Application by Oaklands Farm Solar Limited for an Order Granting Development Consent for Oaklands Farm Solar Park Issue Specific Hearing 1 action points

Date of hearing: Tuesday 22 October 2024 and Wednesday 23 October 2024

Figure 4 Assessed road receptors

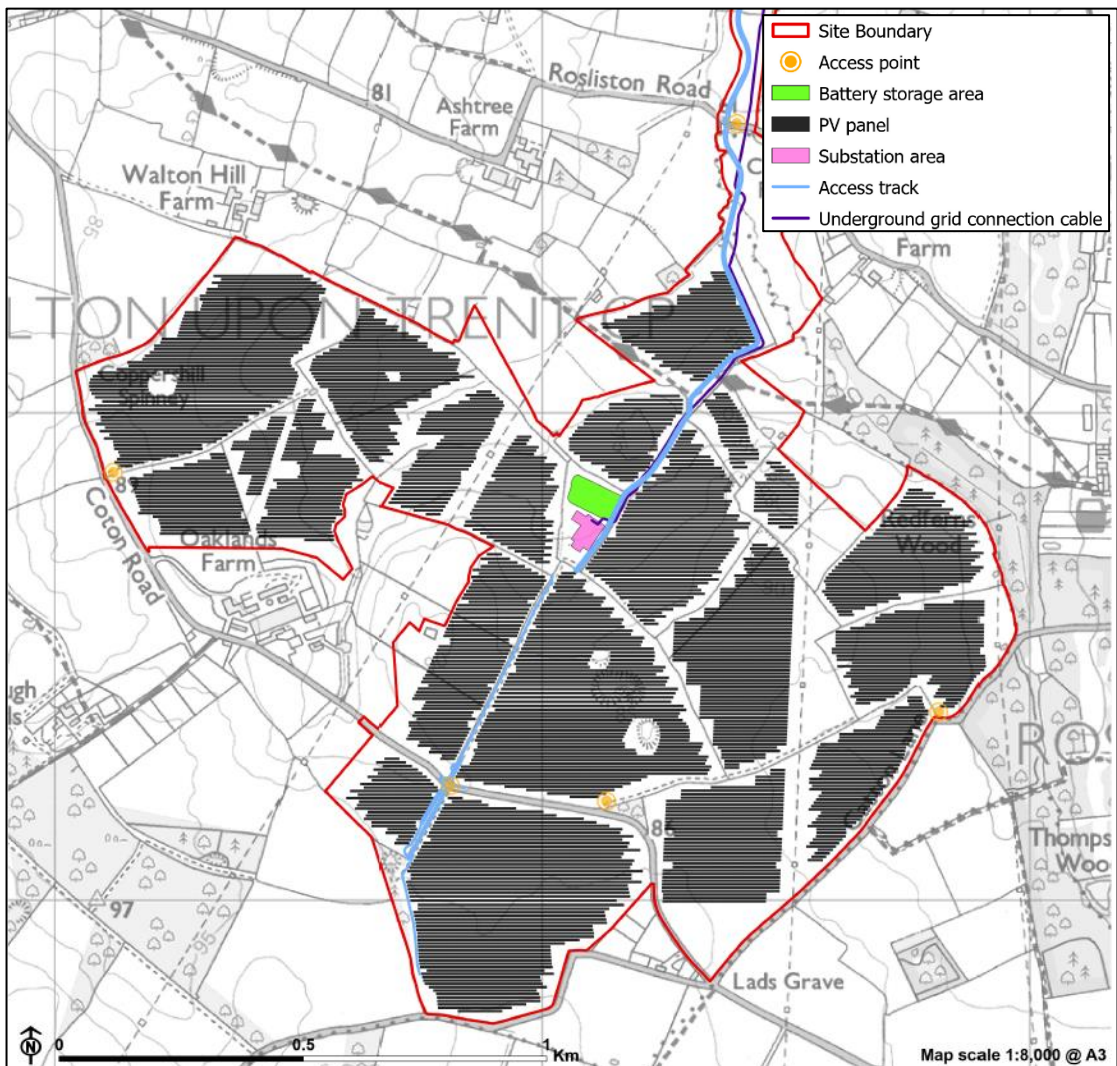
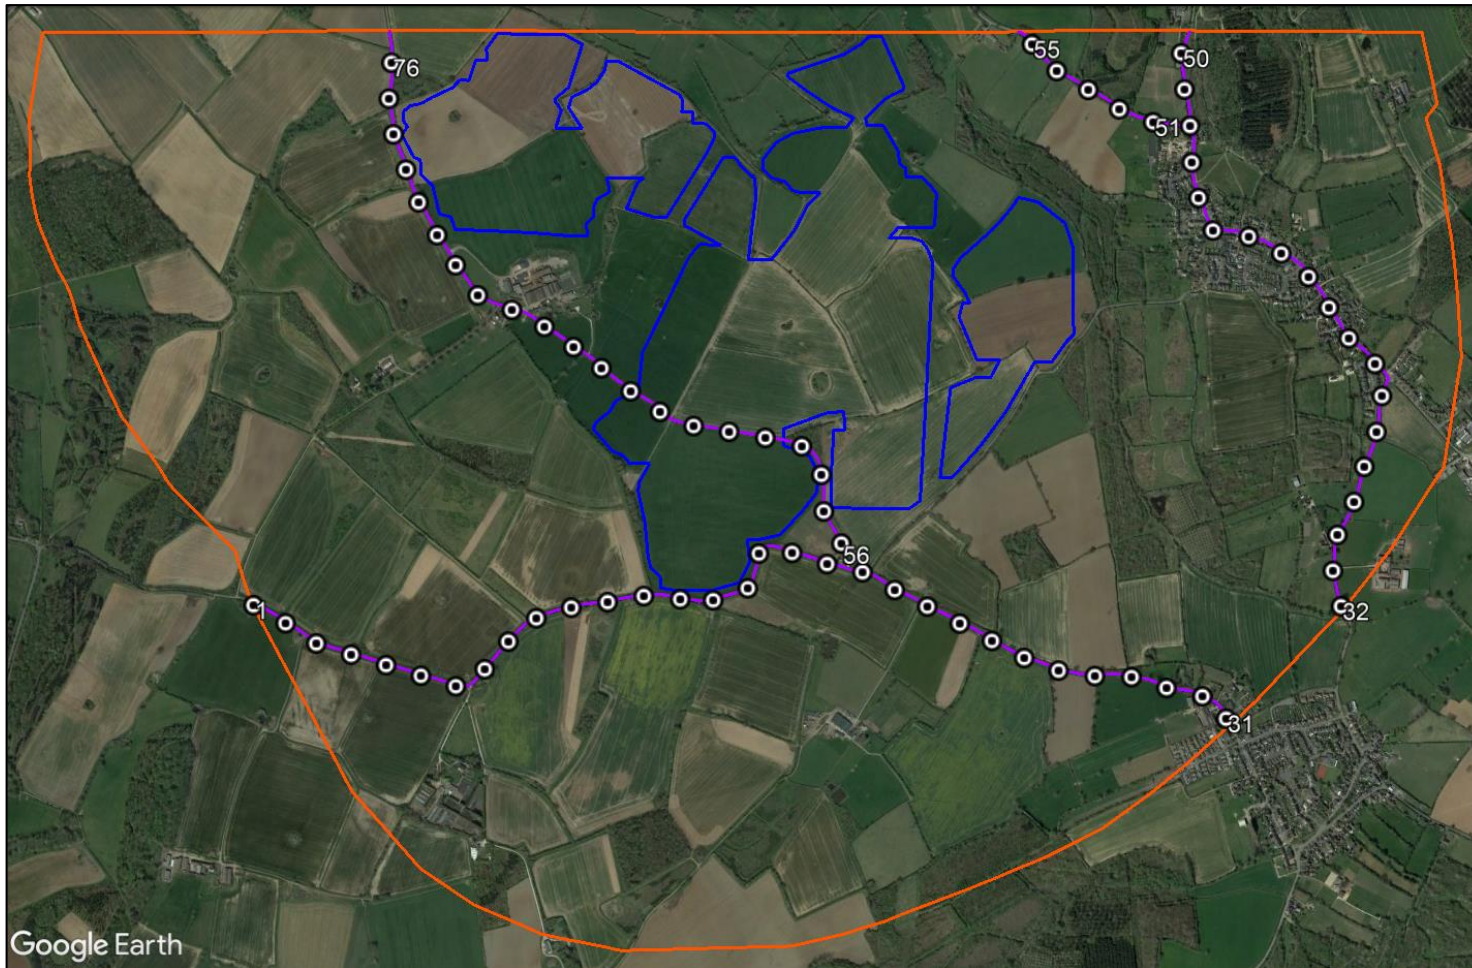
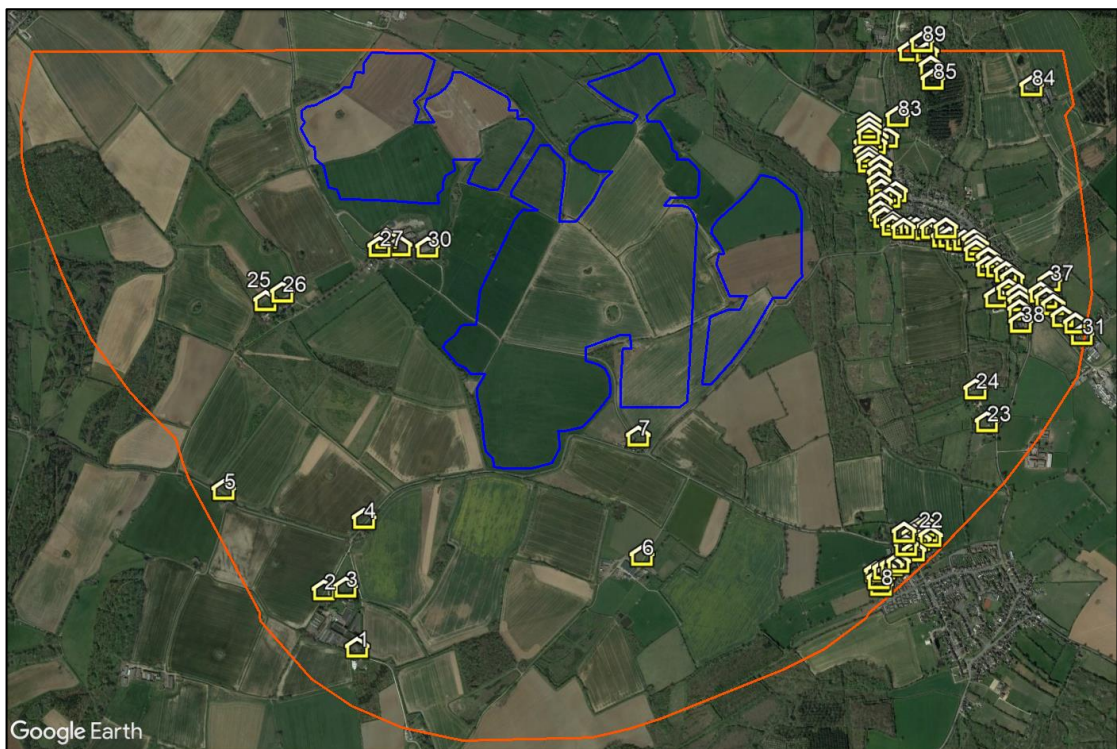
c)	Applicant SDDC	Reconsider the responses [REP4-011] and quantitative evidence provided in response to concerns about glint and glare, including in relation to modelling reflections from mid-height of the panel rather than the top, only considering the ground floor of dwellings as possible receptors, local road users being given a low sensitivity, and significance of effect thresholds and the use of best practice guidance (Applicant). Provide the details of any independent reviews undertaken of the glint and glare assessment (Applicant, SDDC).	D5
